V5_Civil CDs_comments.pdf Markup Summary

CARUBIA PROPERTIES - GRADING AND EROSION CONTROL SITE DEVELOPMENT CONSTRUCTION PLANS

LOT 2, BENT GRASS EAST COMMERCIAL FILING NO. 4

PPR256

INTERIM GEC PLAN  
CARUBIA PROPERTIES  
LOT 2, BENT GRASS EAST COMMERCIAL FILING NO. 4  
COUNTY OF EL PASO, COLORADO

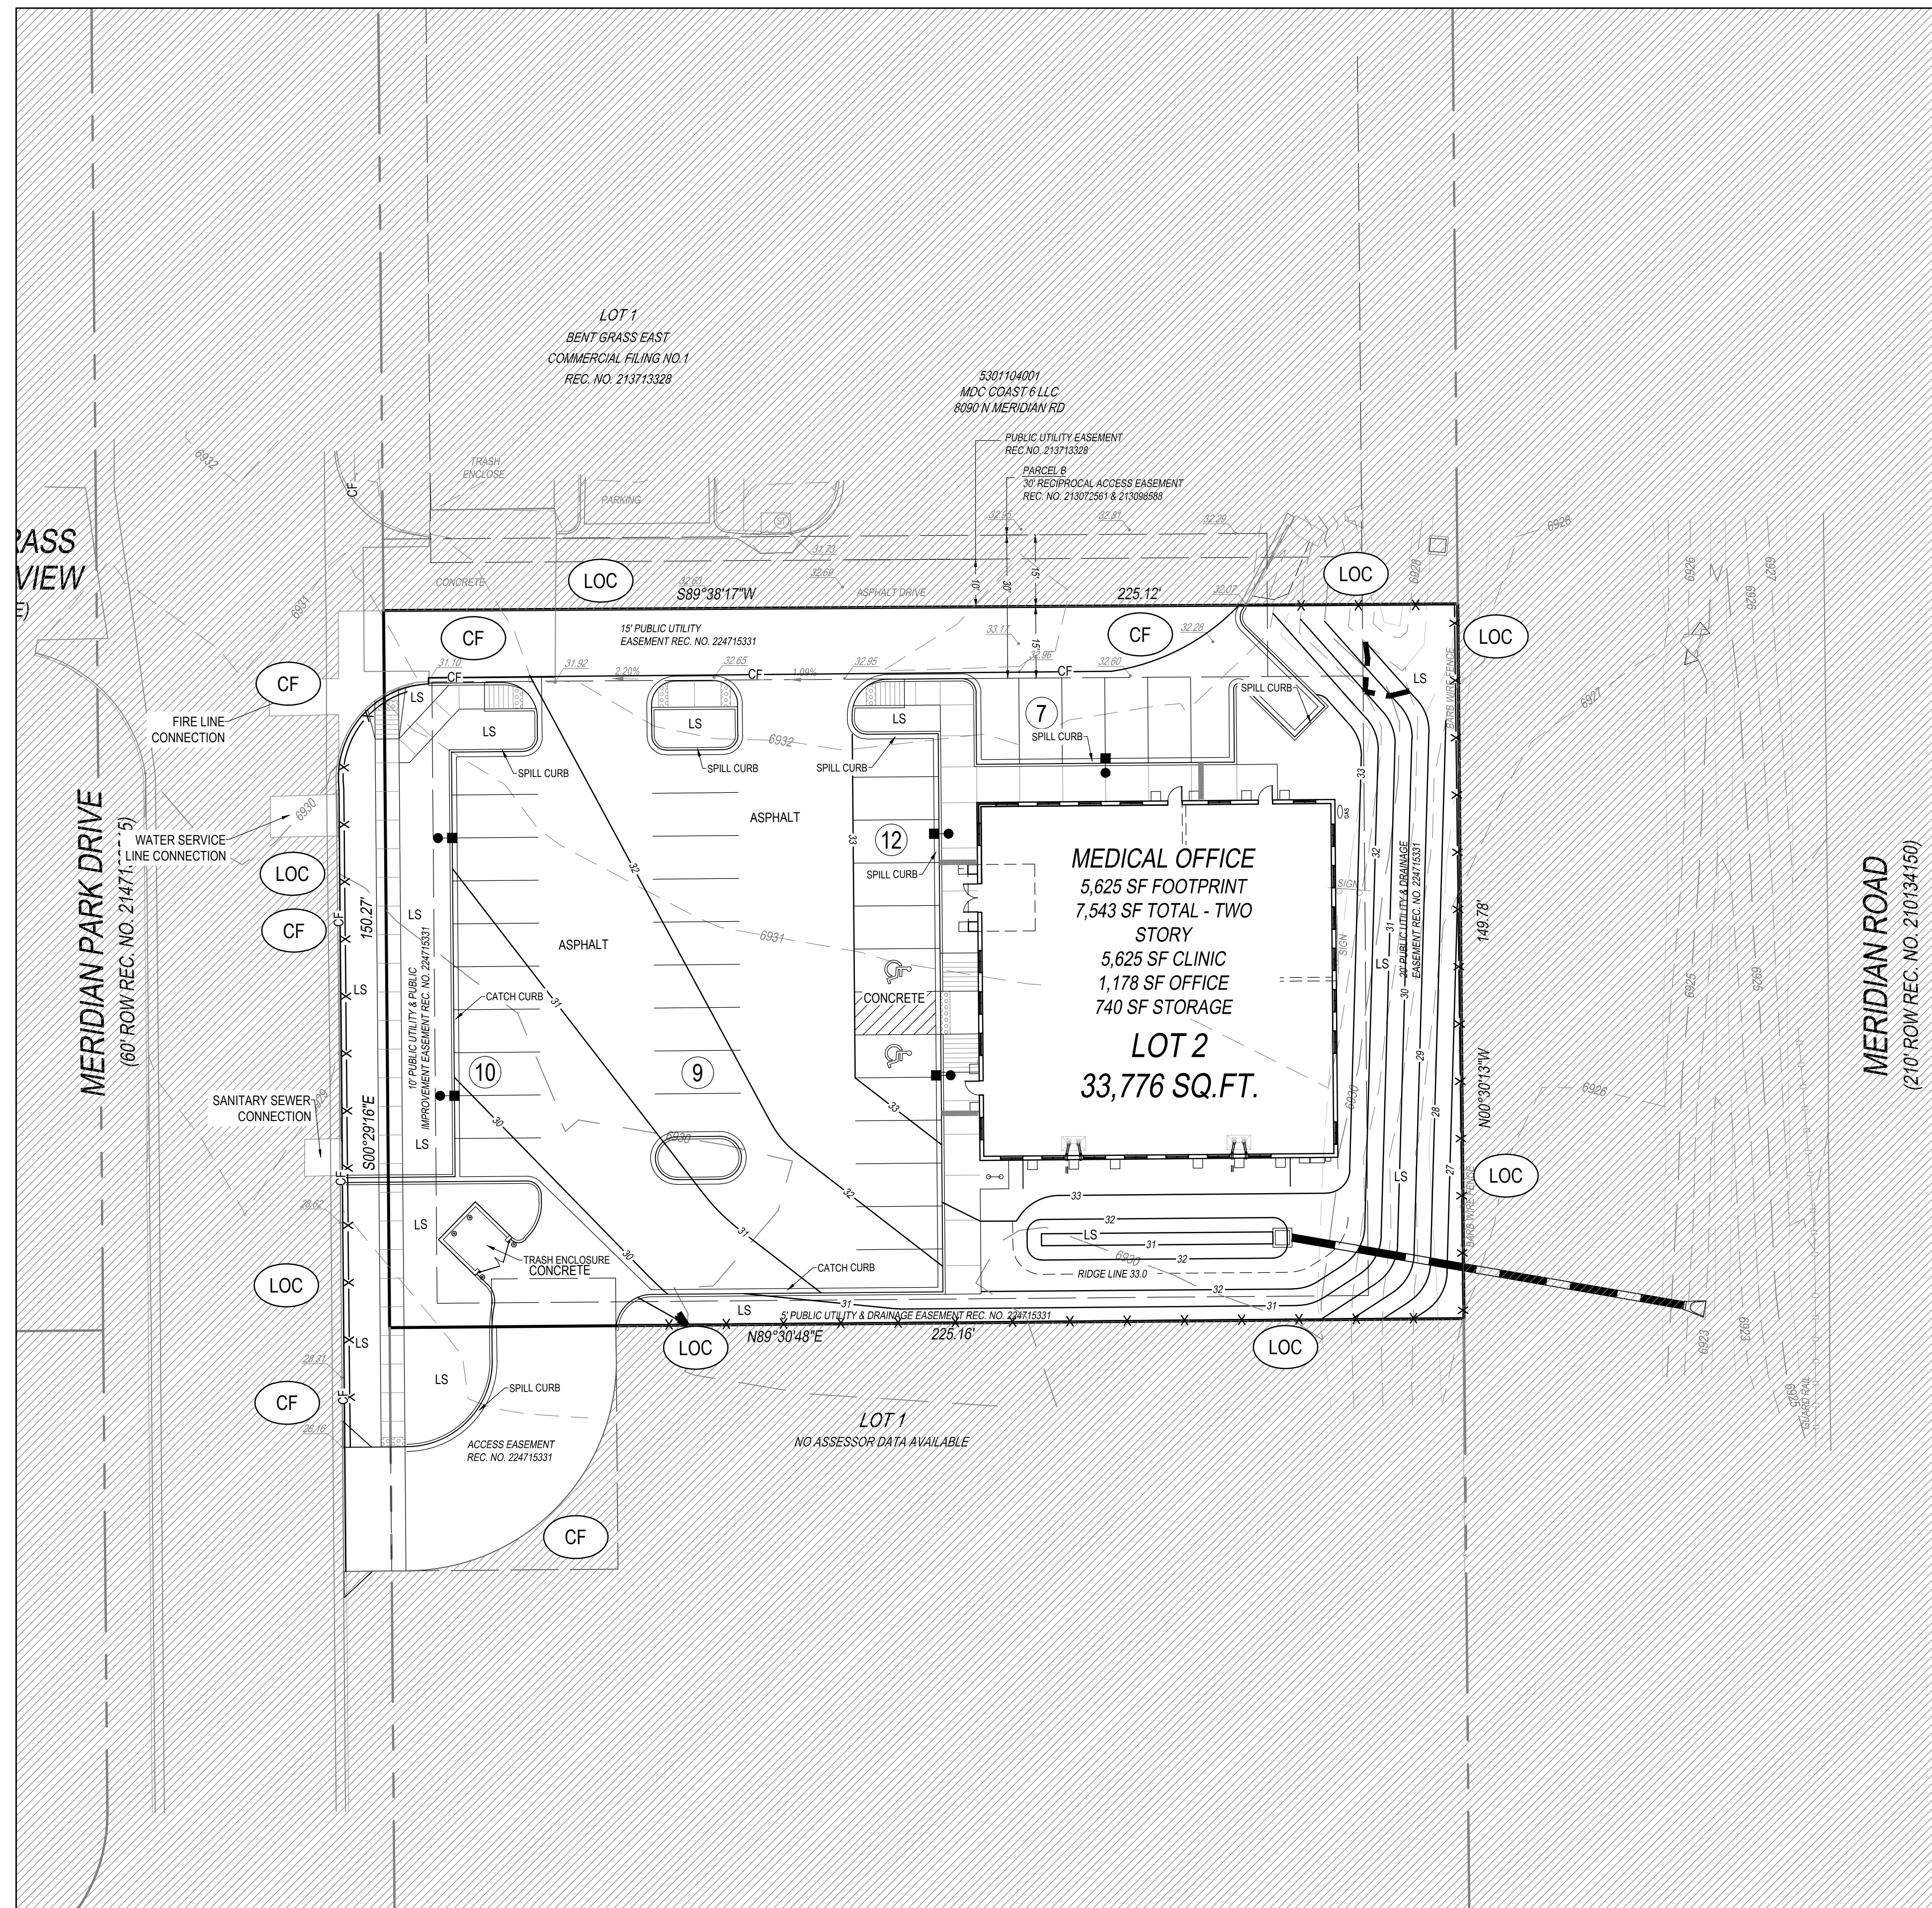
How this plan view, revise shape of both grass swales and inflows (and lack of level spreaders) per all my comments in the MHFD calcs in the Drainage Letter.

This SPA was appropriately shaded in pink with the last submittal. What happened? Please rectify.

Still unresolved comment from previous two reviews: specify depth of riprap too

Per the MHFD recommendation in the spreadsheet comment for this row, 2ft spacing on center is recommended.

You inputted 1' openings in the MHFD calcs. Revise to remove discrepancy. MHFD rec's 1.5' opening to protect from snow plow damage

MHFD recommends this be a vertical drop. In this case, there is high potential that the interface between the pavement/curb and the rock would get backed up with debris along the rock. With a vertical drop, this risk is much lower.

Per the blue shading on the next sheet, some of this area shown with SM hatching is actually rock. Please revise SM hatching and label/hatch as rock to account for this.

revise inflows as needed per my comments in the MHFD calcs in the Drainage Letter.

Per MHFD guidance, Grass Swales are to be trapezoidal shaped.
